**EN010122 – APPLICATION FOR A DEVELOPMENT CONSENT ORDER FOR OAKLANDS FARM SOLAR PARK, SOUTH DERBYSHIRE**

**PLANNING ACT 2008 (AS AMENDED) – SECTION 51 SUBMISSION**

- 1.4 – Application Guide;
- 2.2 - Land Plans;
- 2.3 – Works Plan;
- 2.4 – Streets, Access and Rights of Way Plan;
- 3.1 – Draft Development Consent Order;
- 3.2 - Explanatory Memorandum;
- 4.3 - Book of Reference;
- 5.1 – Consultation Report – an amended May 2024 version of the Main Statement;
  - Appendix 10.3 - Section 42 Letter to Landowners, occupiers and those with an interest 20 April 2023;
  - Appendix 11.2 - Final Published Statement of Community Consultation (SoCC);
  - Appendix 11.16 - Statutory Consultation Virtual Exhibition;
- 6.1 – Environmental Statement - May 2024 versions of:
  - Figure 10.1 – 10.9 – Air Quality Management Areas
  - Appendix 8.1 – Flood Risk Assessment
- 6.2 – Non-Technical Summary;
- 9.1 – this S51 Covering Letter;
- 9.2 – Crossing Method Statement.

Drawing Title
**Works Plan
 Sheet 3**

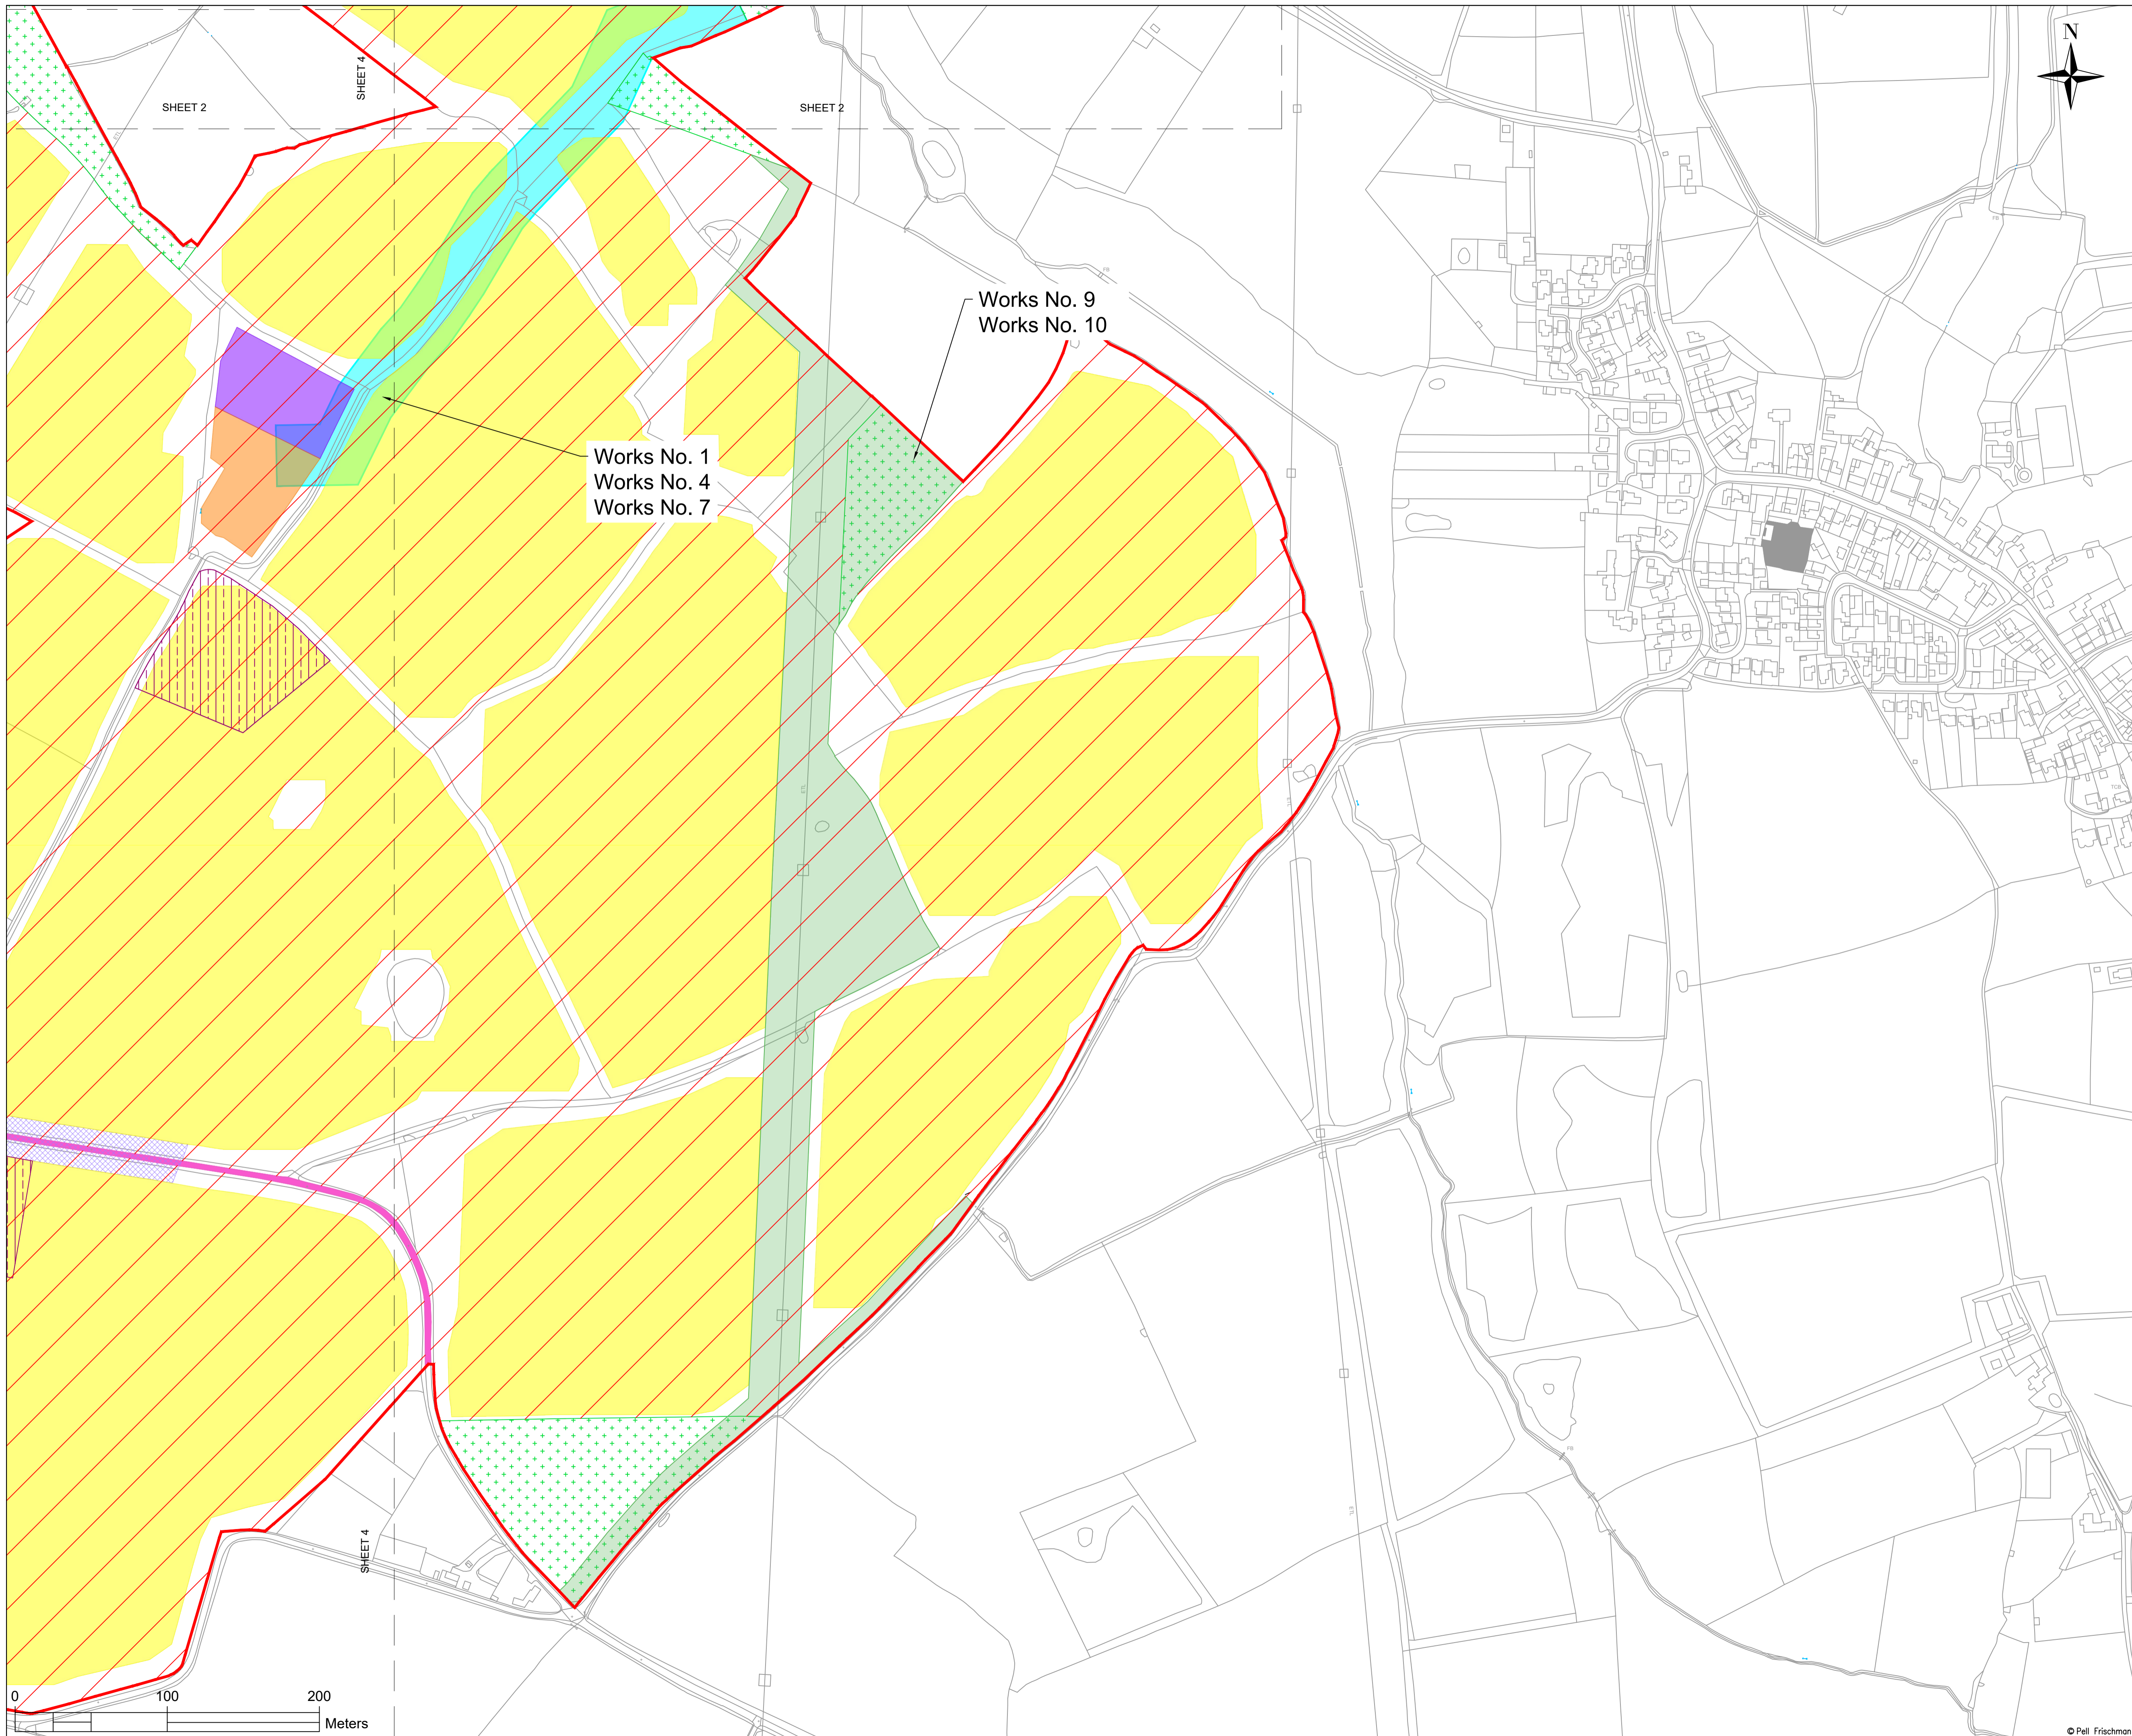
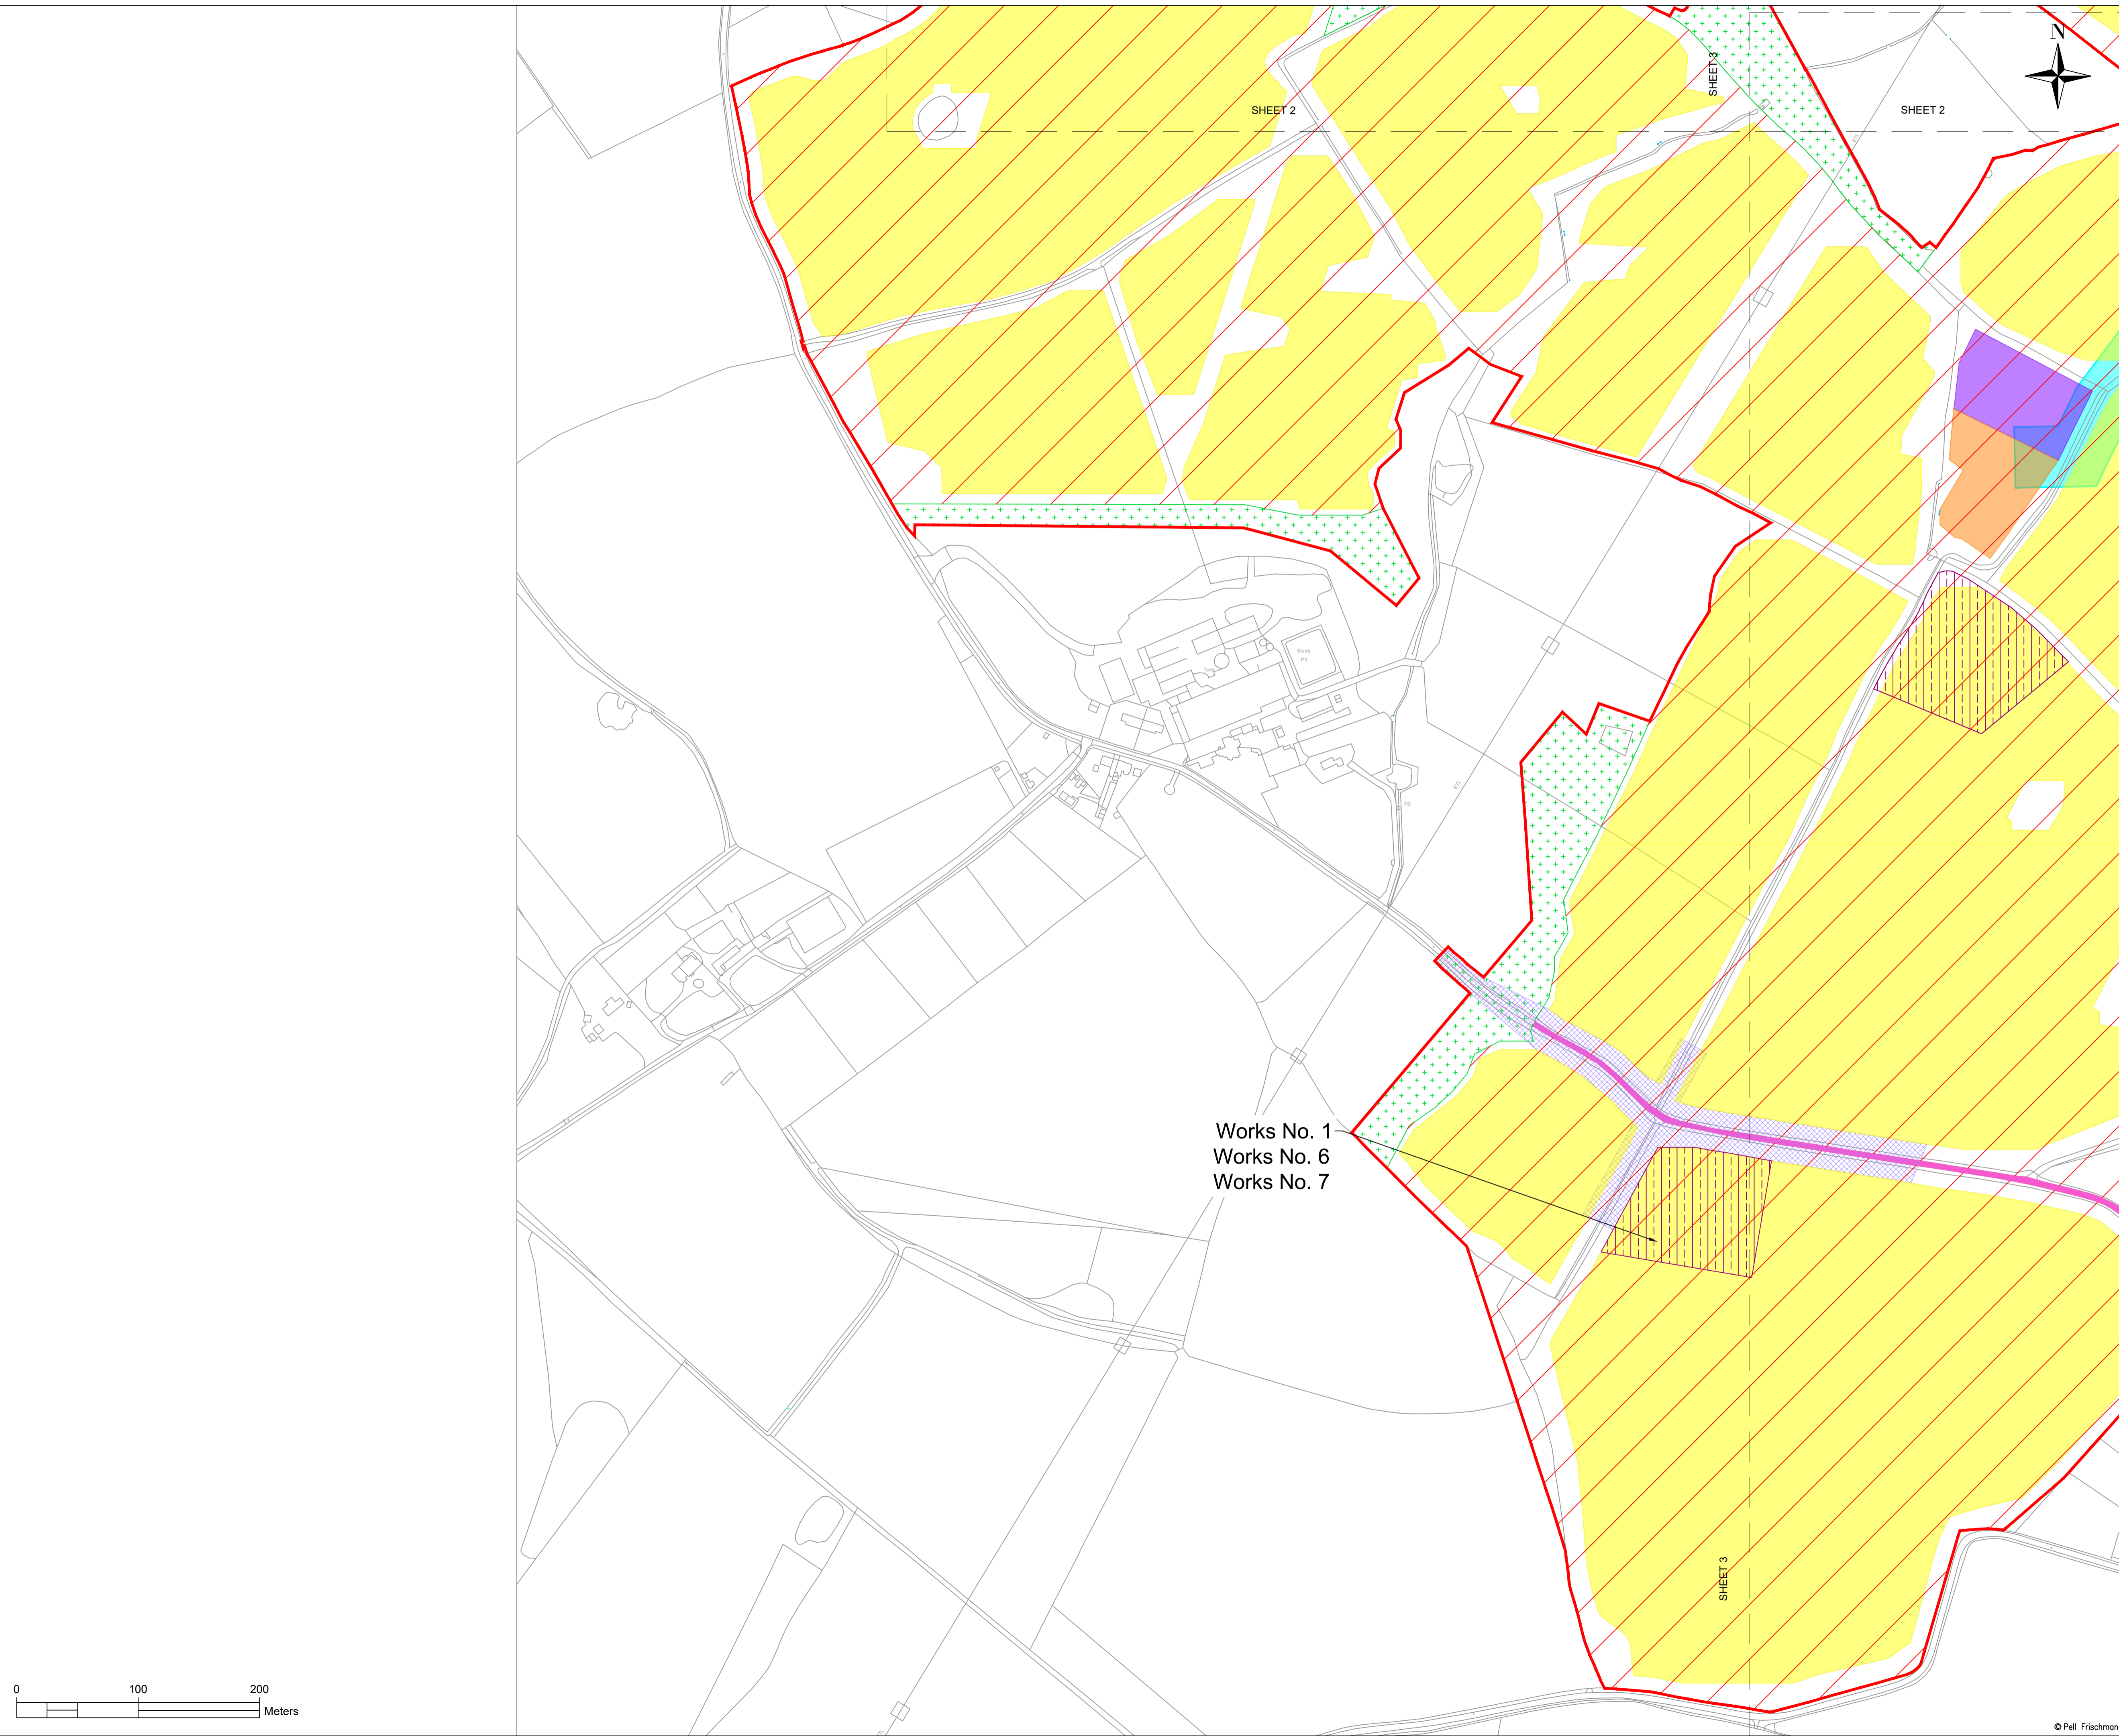
Works no. 2, 3, 4d, 6 and 8 are now labelled on Sheets 3 and 4 and the roads referred to in the draft DCO are now clearly named on the Works Plan.

Figure 10.5: Location of Sensitive Receptors

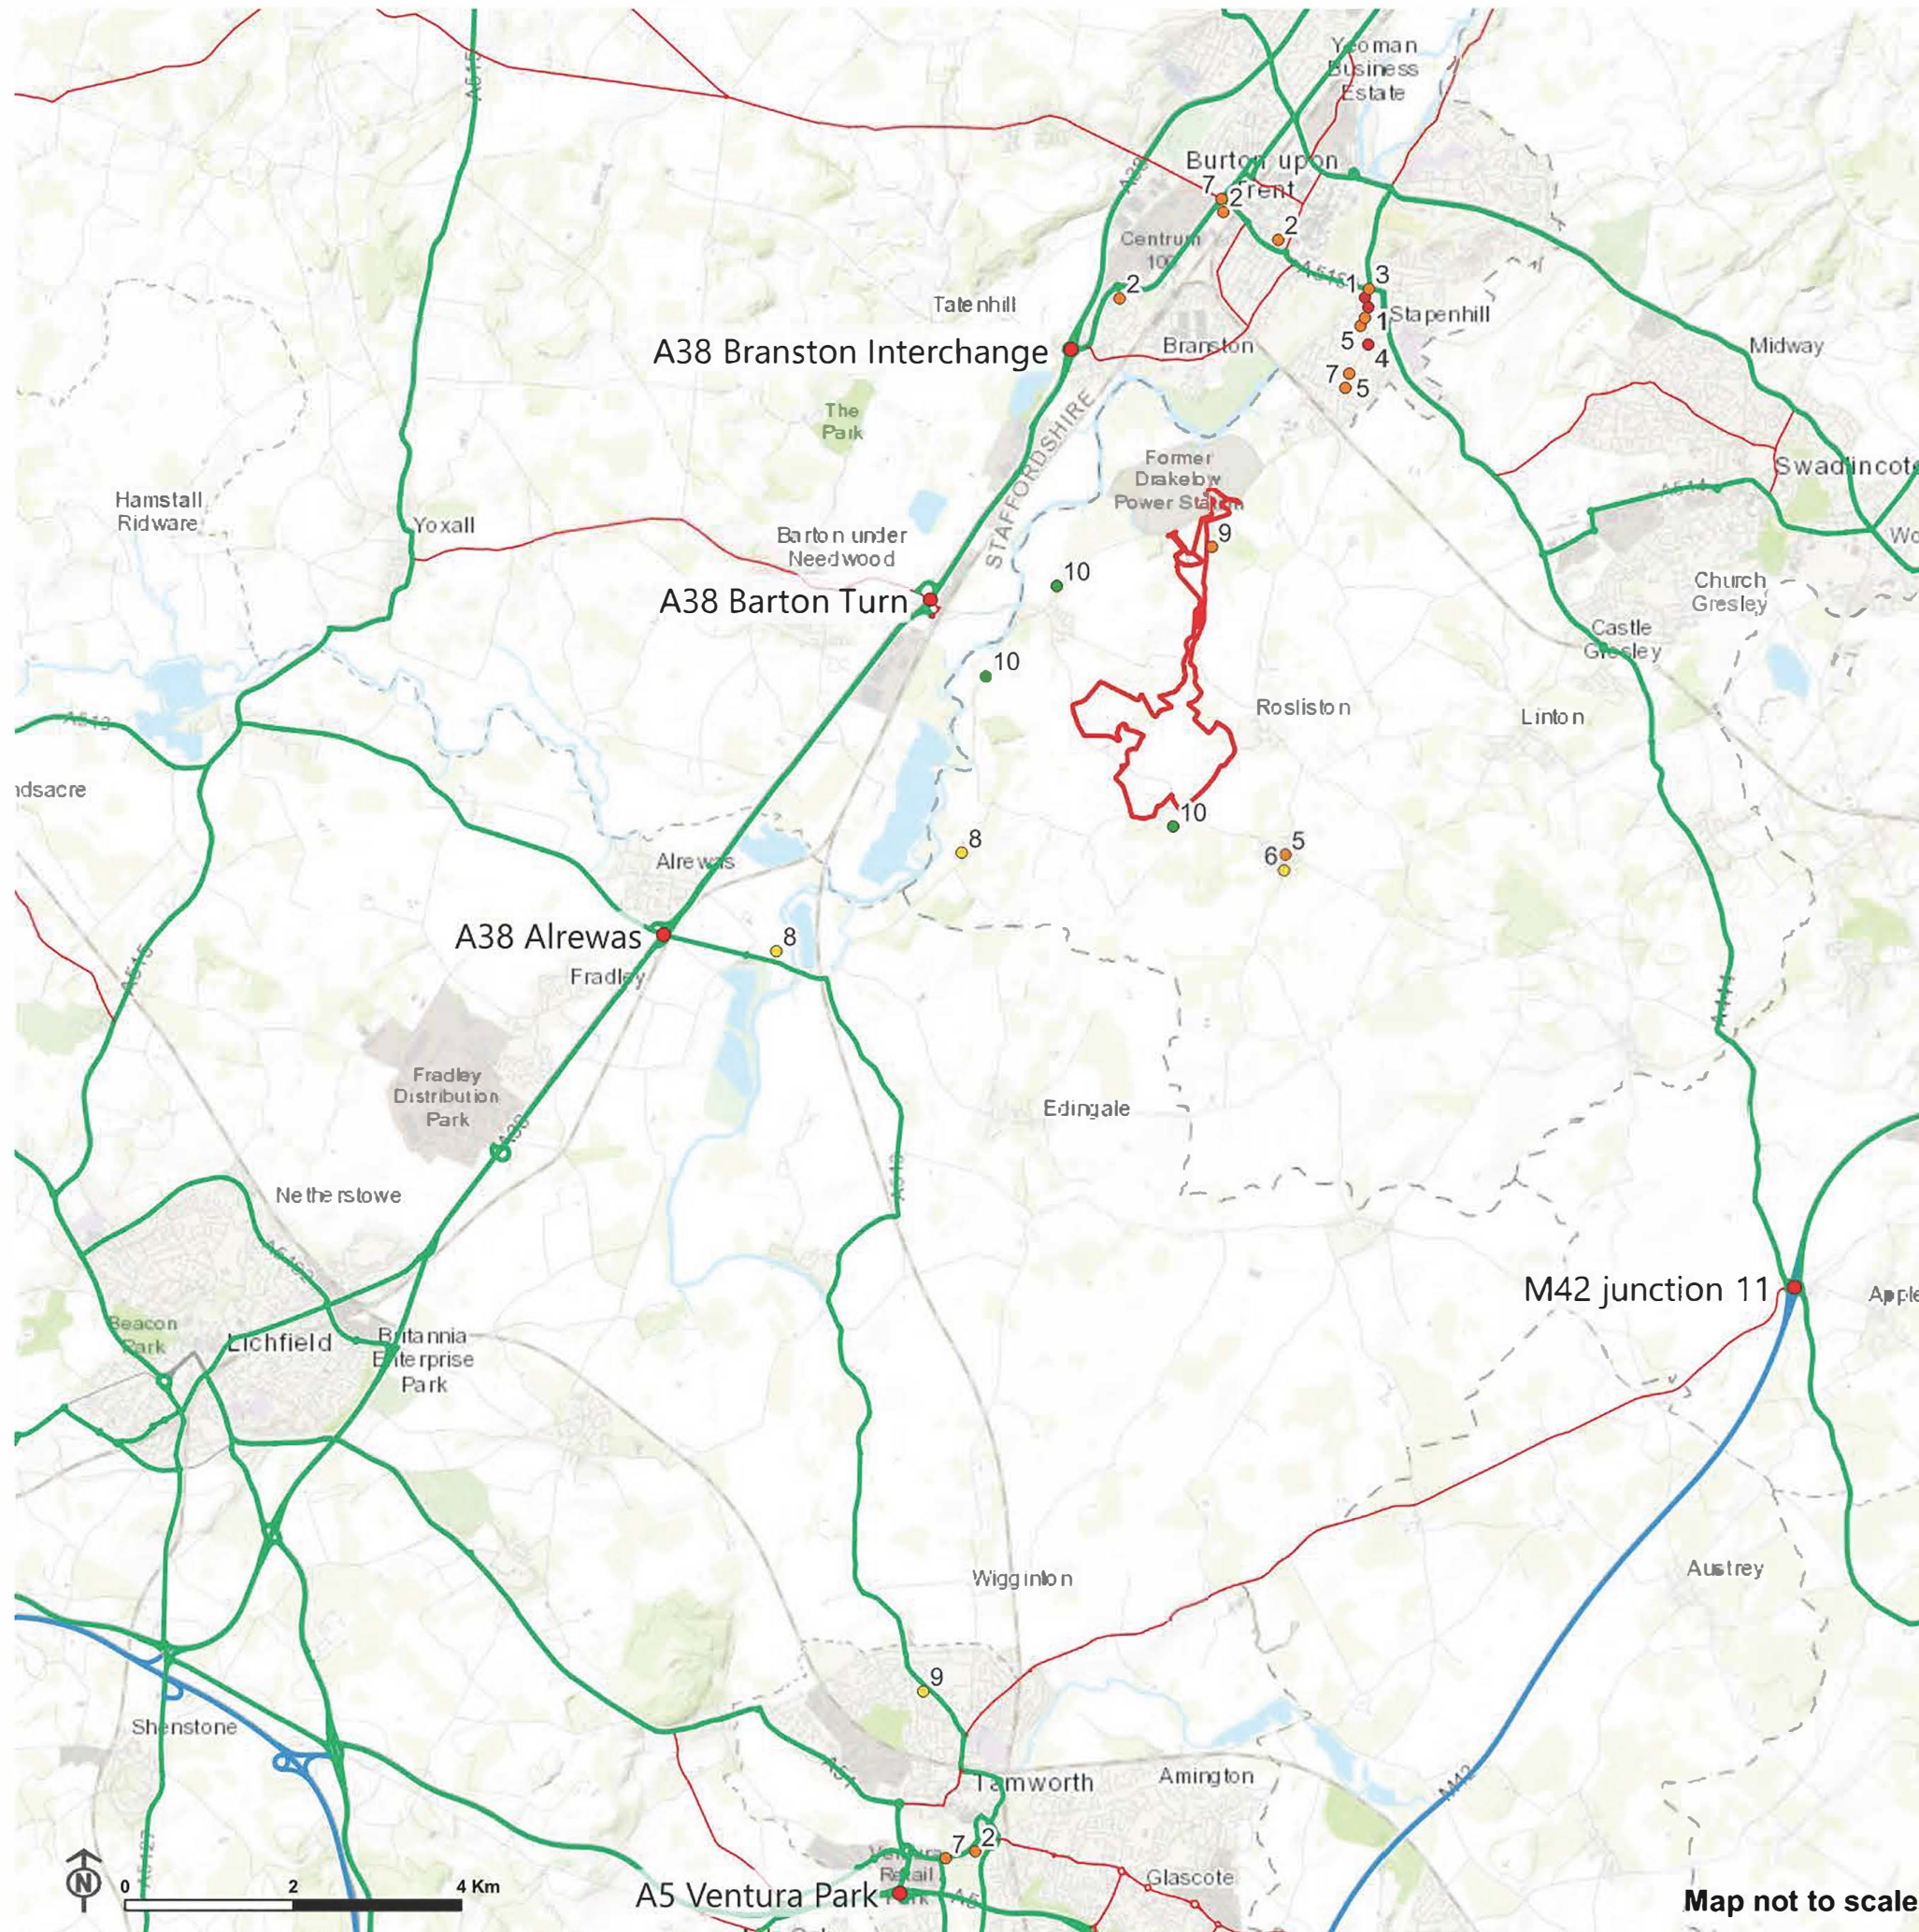
Figure 10.5 has been amended to show both AQMAs and their extents. The whole document which encompasses Figures 10.1 – 10.9 has been provided so that it can easily supersede the original version, but for clarity only Figure 10.5 has been amended.
